CITY OF ALBUQUERQUE

November 6, 2018

RE: **Highland High School Title IX Gymnasium Upgrade-Phase 2**
4700 Coal Ave SE
Requested Temporary C. O. – Accepted
Engineers Stamp Date 6/23/16 (K17D021)
Certification dated: 11-1-18

A1 GRADING PLAN
SCALE: 1:20_XREF

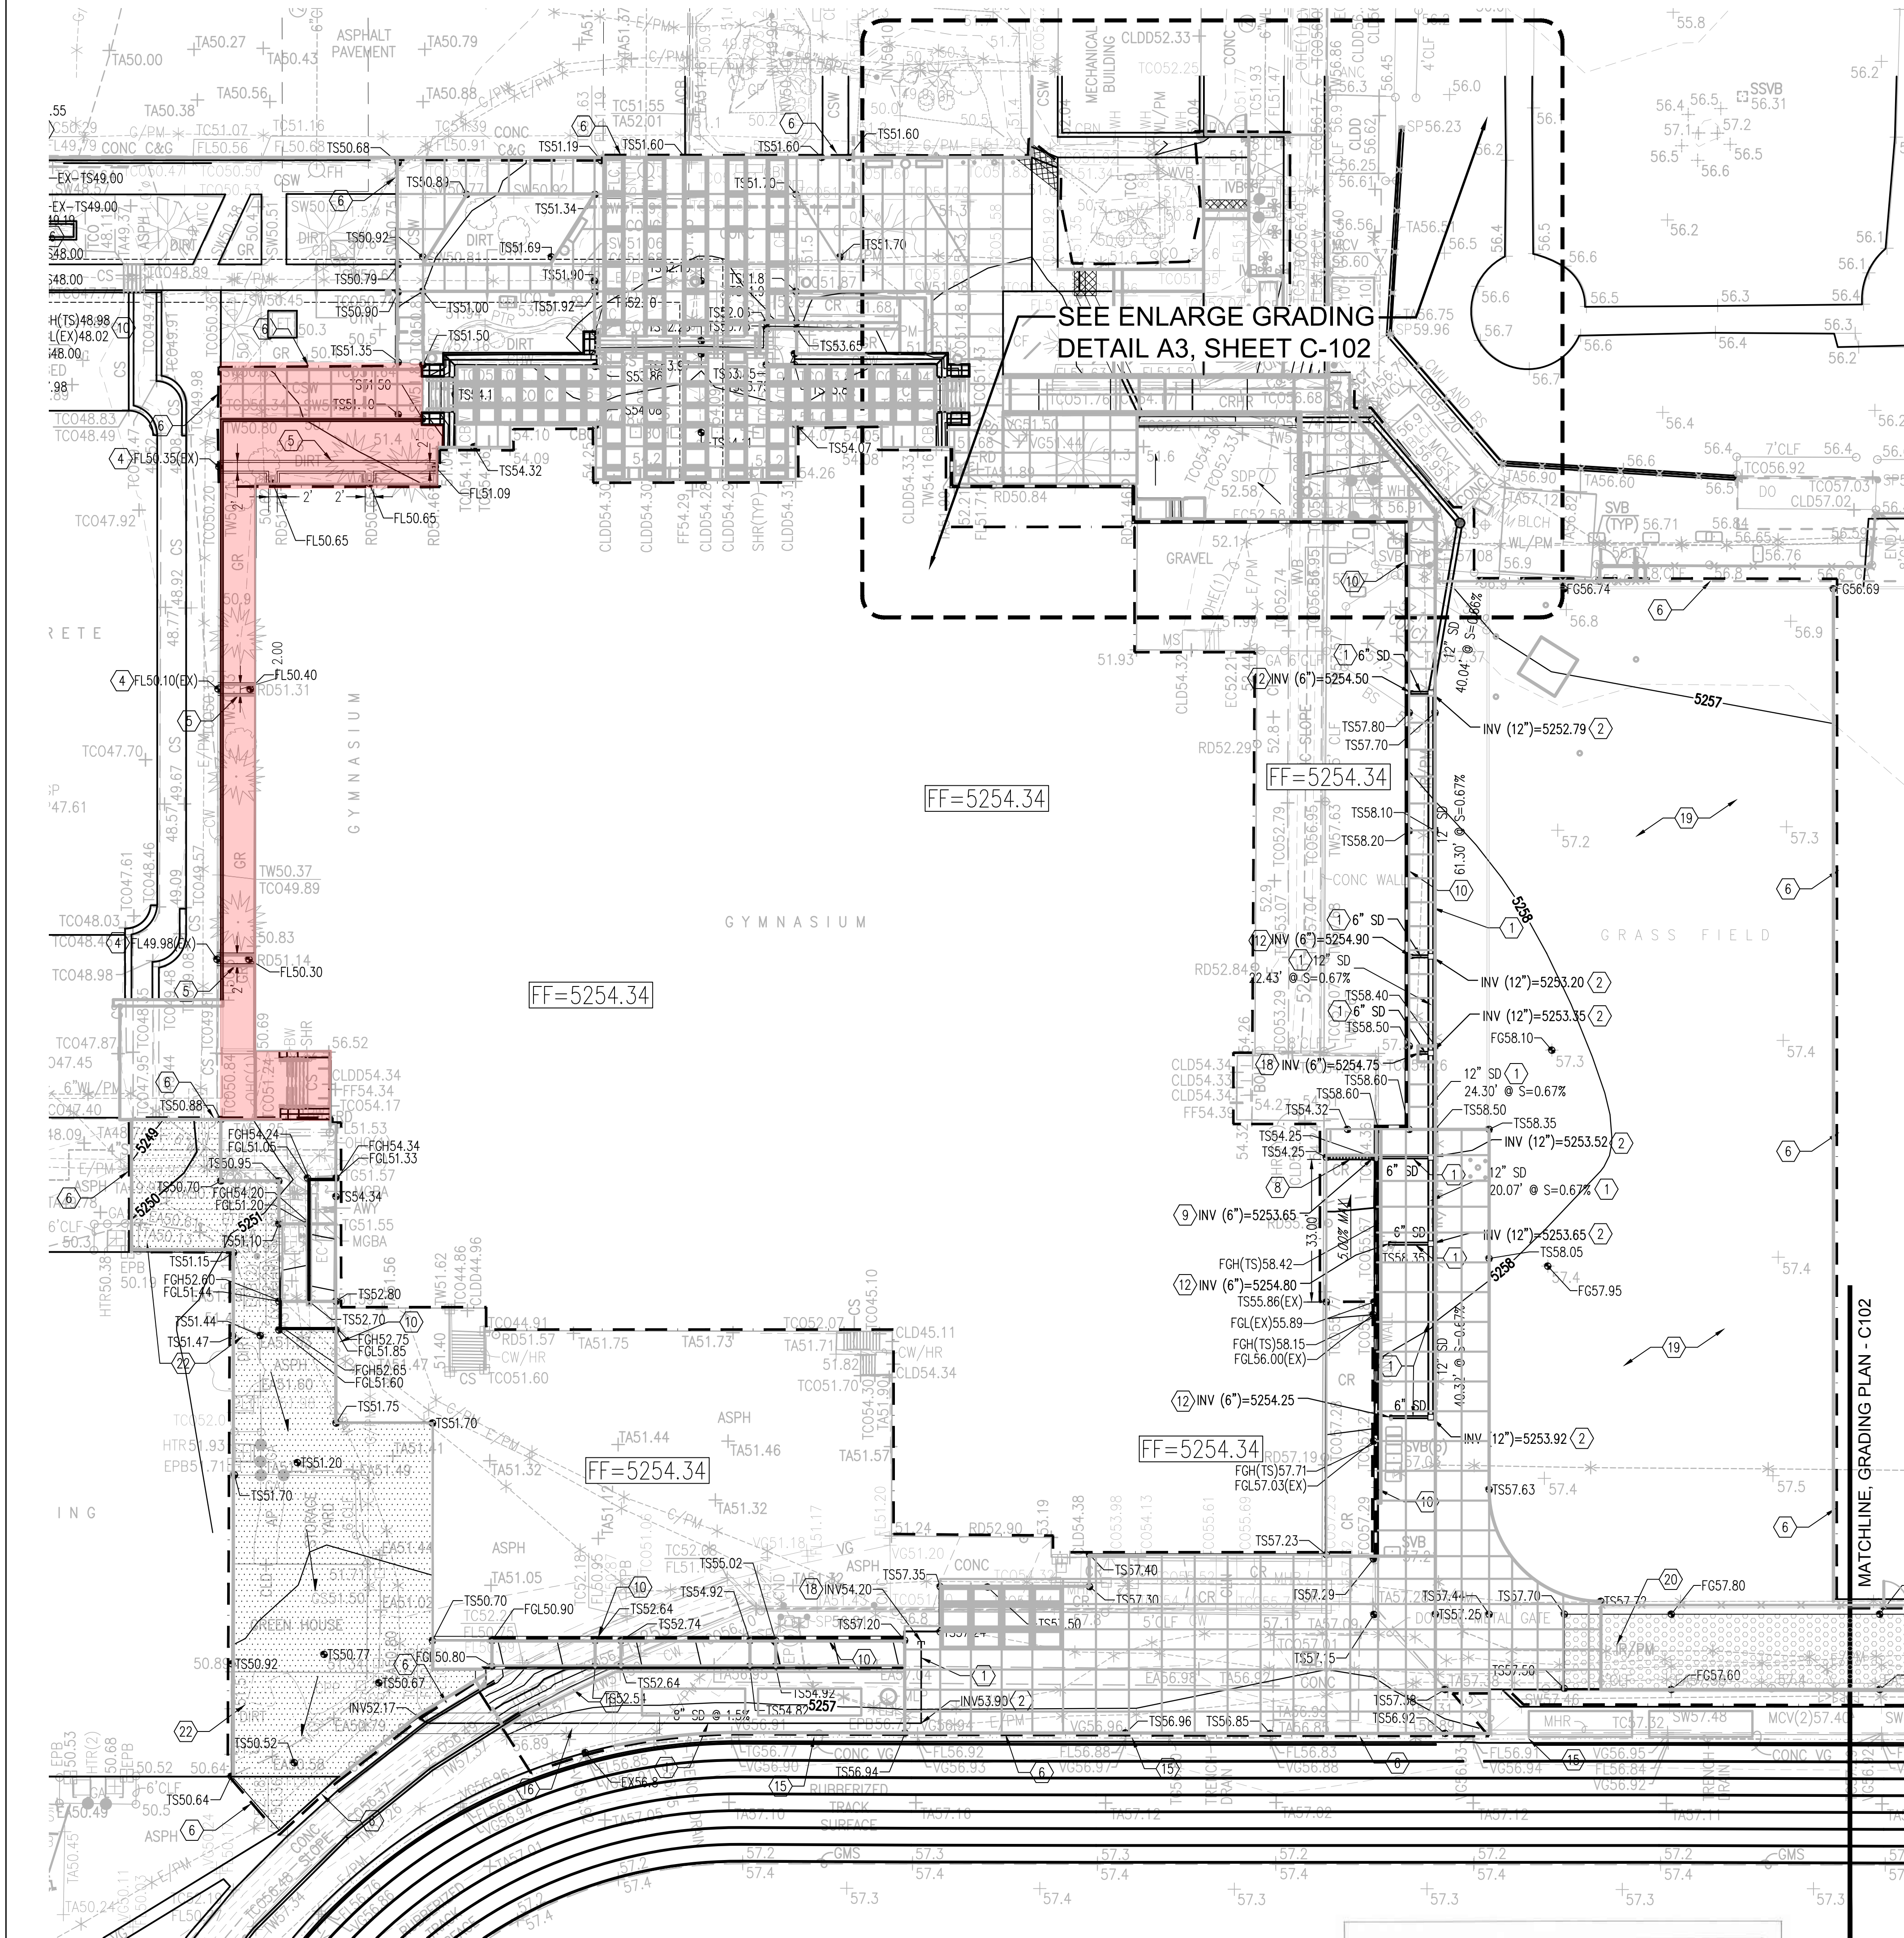
- All construction fencing is to be removed from Phase 2. See attached pic.
- The storm drain next to the ramp must be as-built on submittal.
- The roof drains in Phase 3 must be complete and not directing flows into Phase 2.
